From: Sue Howell <Sue.Howell@arun.gov.uk>
Sent: 21 February 2022 14:31
To: Planning.Responses <Planning.Responses@arun.gov.uk>
Cc: Simon Davis <Simon.Davis@arun.gov.uk>
Subject: Planning Consultation on: Y/184/21/DOC

Application ref: Y/184/21/DOC

Description: Approval of details reserved by condition imposed under ref W/4000394 (Y/103/18/PL) relating to Condition Nos 5 - Construction & Environmental Management Plan, 8 - surface water drainage, 9 - discharge flows to watercourses, 10 - maintenance & management of surface water drainage, 12 - monitoring regime, 13 - landscaping, 14 - materials & finishes, 15 - landscape management plan and 20 - external lighting.

Location: 10 Acre Field Grevatts Lane West Yapton Bognor

project				
BOGNOR REGIS CREMATORIUM				
client				
WESTERLEIGH				
drawing title				
LANDSCAPE MASTERPLAN				
drawing number	revision	status	scale	
954-MP-01	D	PLANNING	1:500 @ A1

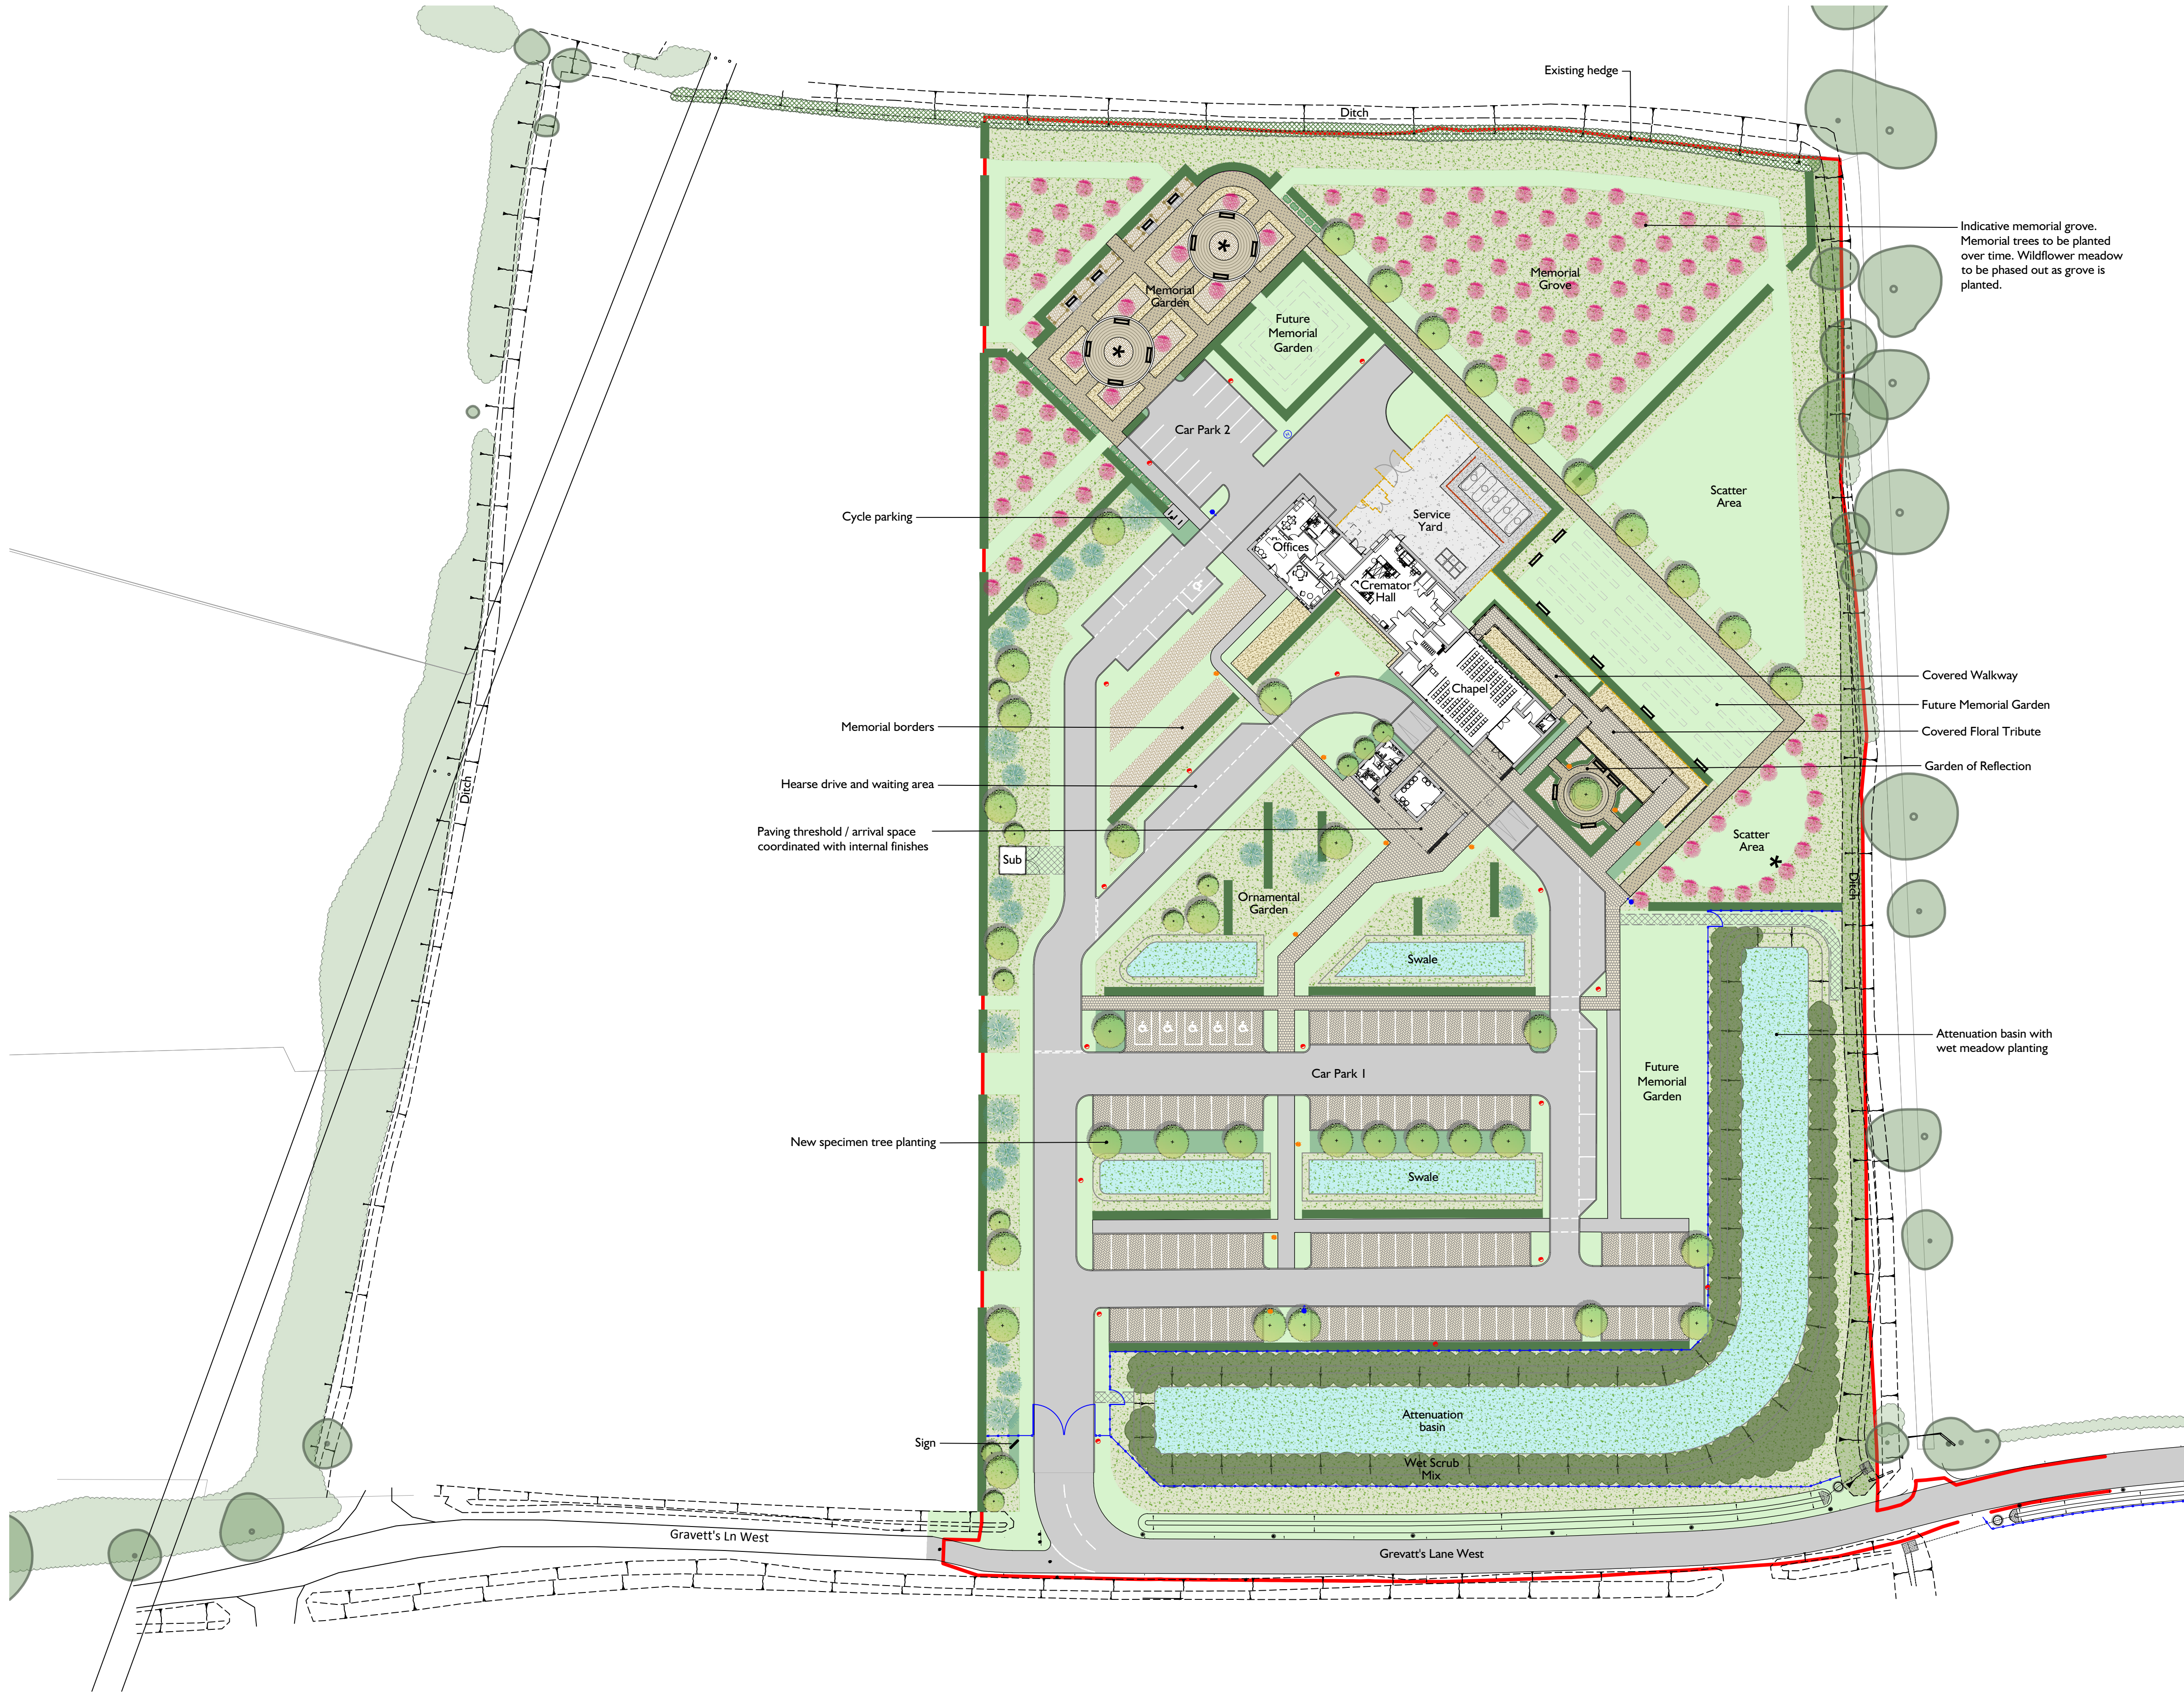
- The information submitted within the Landscape Masterplan Dwg No 954-MP-01 Rev D has provided a comprehensive indicative view of the landscape proposals, which in general appear suitable for location in mix of native and ornamental elements suitable for the various aspects of the development. The information however is indicative and further detail will need to be submitted re species choice, actual quantities and size at time of planting. This is particularly important in relation to the public areas and the boundary treatment where screening and infill planting may need to be provided to the hedgerow boundaries.

Recommend further landscape detail is submitted for approval before Condition 10 can be discharged.
